Comment for planning application 21/01630/OUT

St Laurence, Caversfield

Response to the North West Bicester Development Proposal, Outline Planning Application 21/01630/OUT Amended/ Additional Information 23rd November 2021

February 2022

DRAWING TITLE  
**PROPOSED PEDESTRIAN CROSSING TO CHURCH**

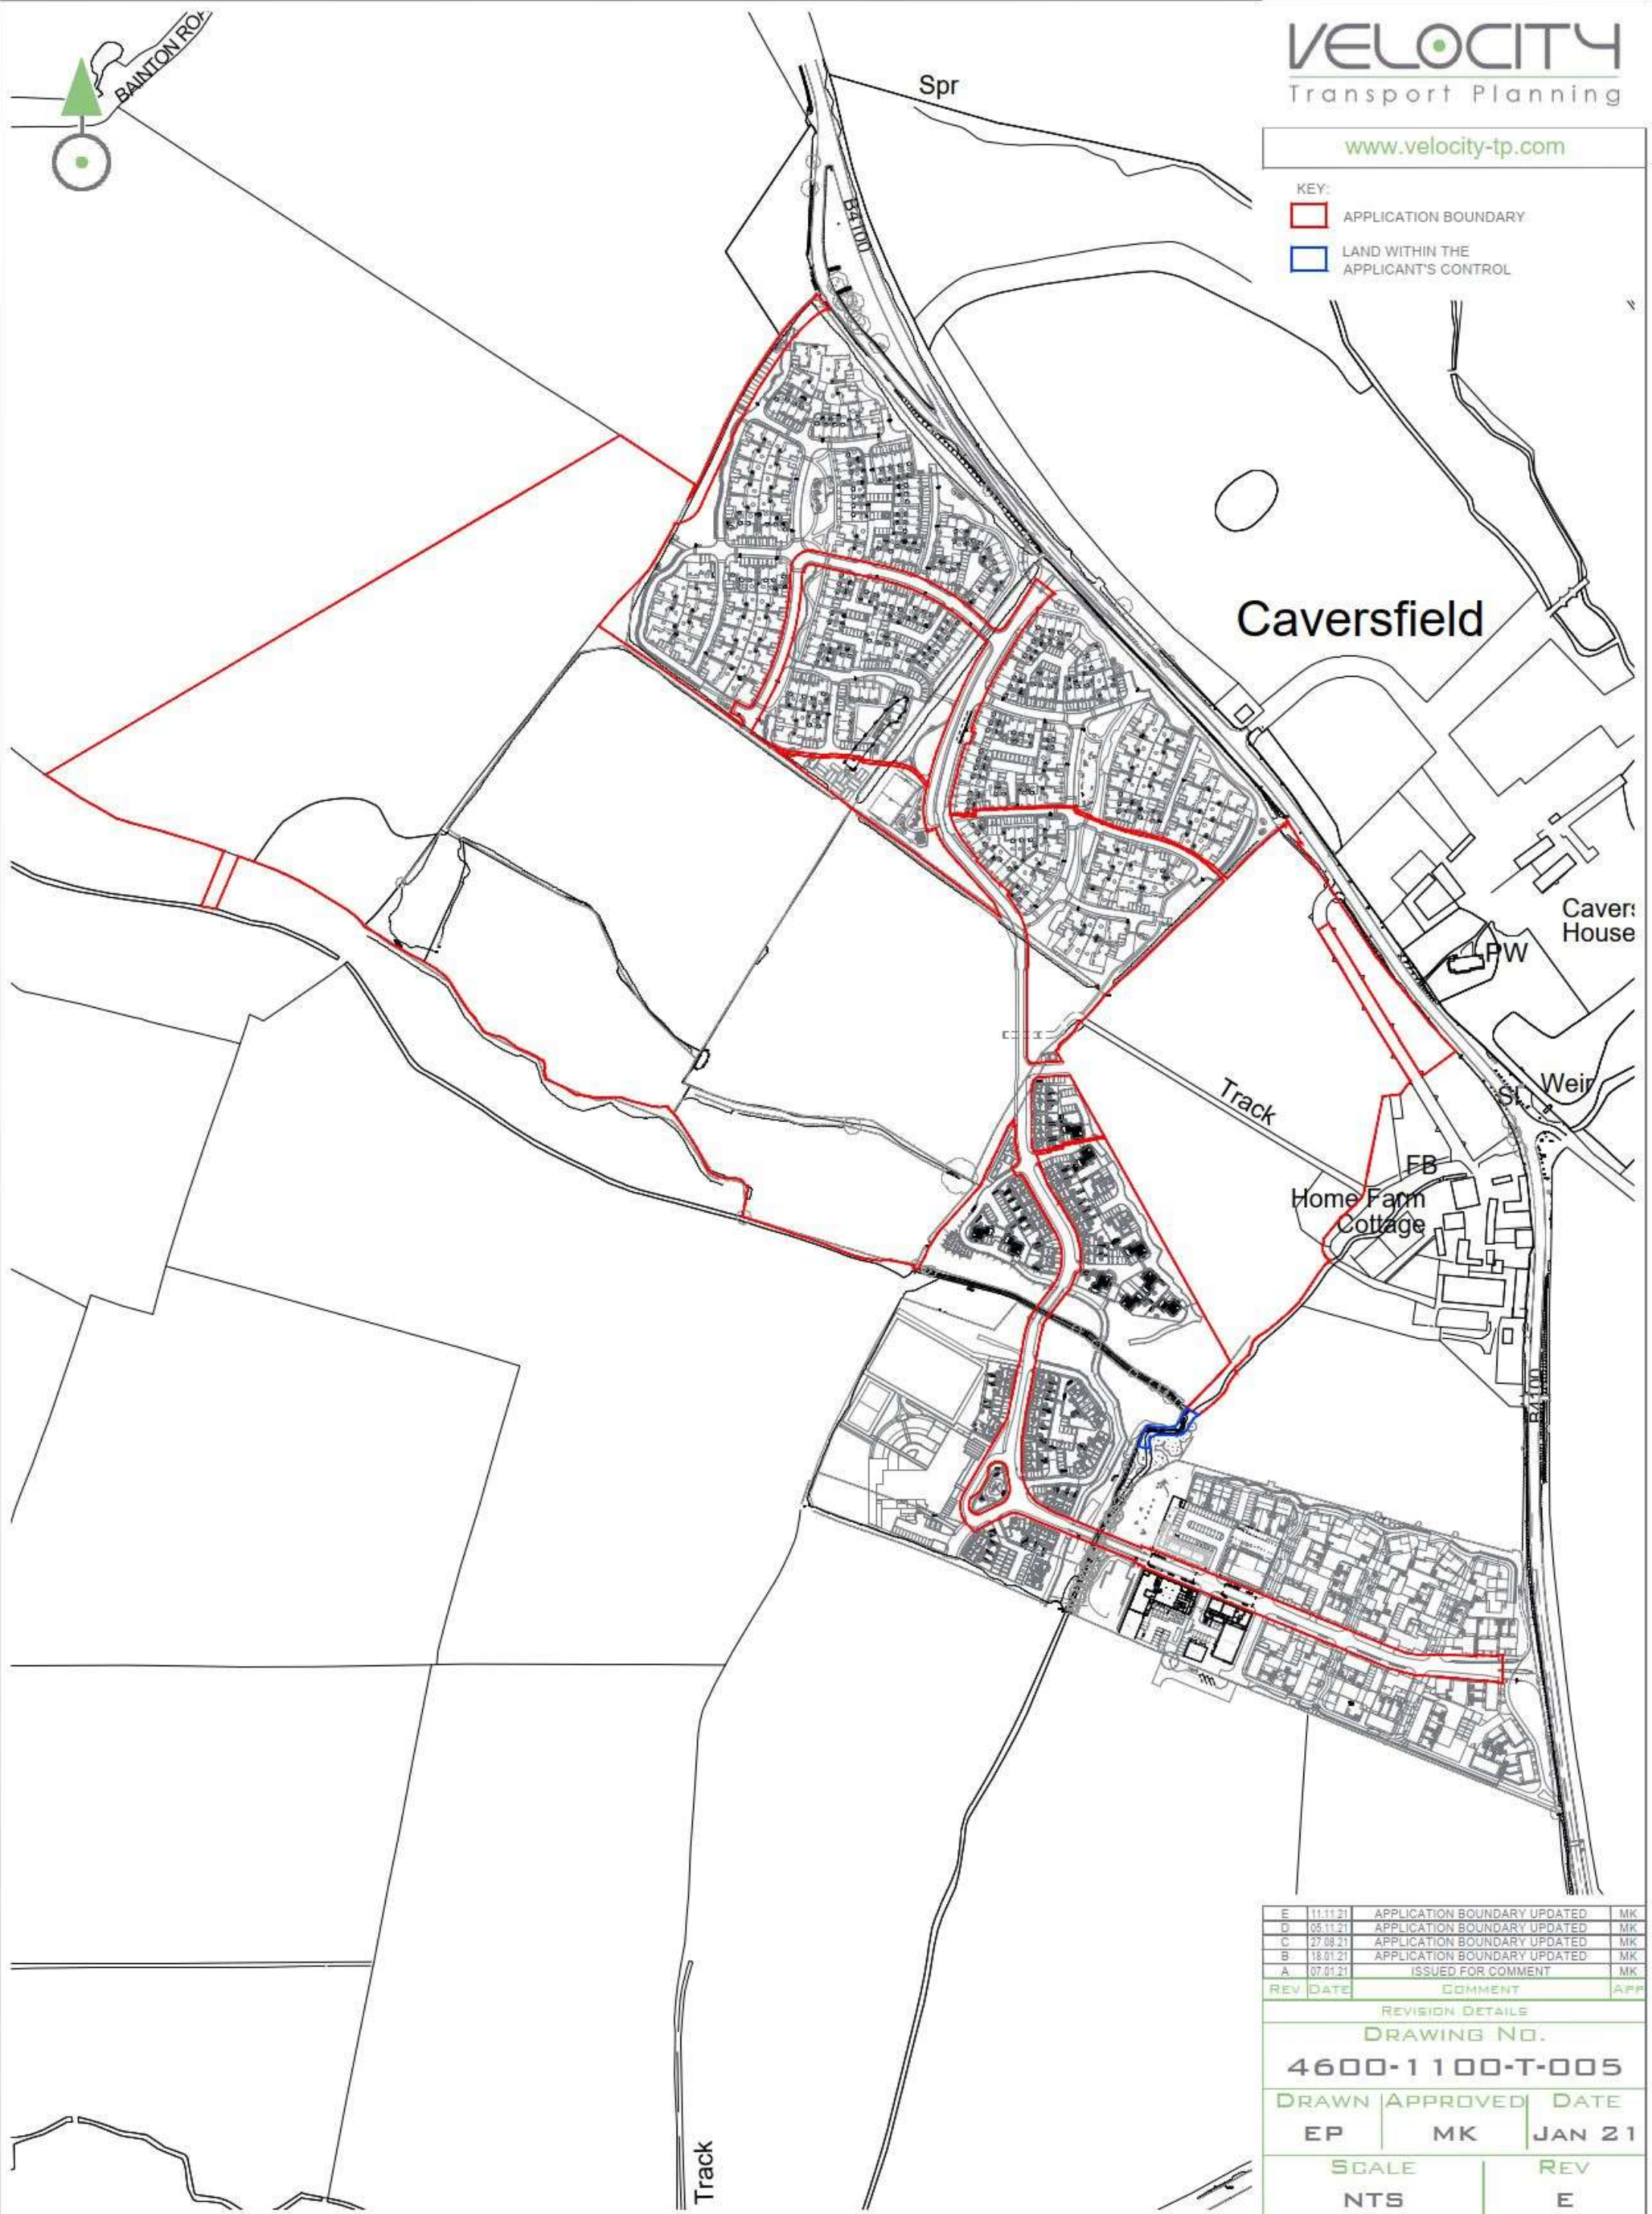
We also warmly welcome the inclusion of a signalised crossing to the church which is to be provided by the developer. We note the comments of the Council's Conservation Officer on the possible impact of a signalised crossing on the view of St Laurence's and agree that this should be minimised if possible. However, if it is not possible to move the crossing because of the topography and relief of the eastern verge of the B4100, we consider that the road safety issues are such that the provision of the crossing is justified. The harm caused by a signalised crossing to the setting of St Laurence's Church, if any, would be minor and would be justified by the undoubted public benefit of the crossing.
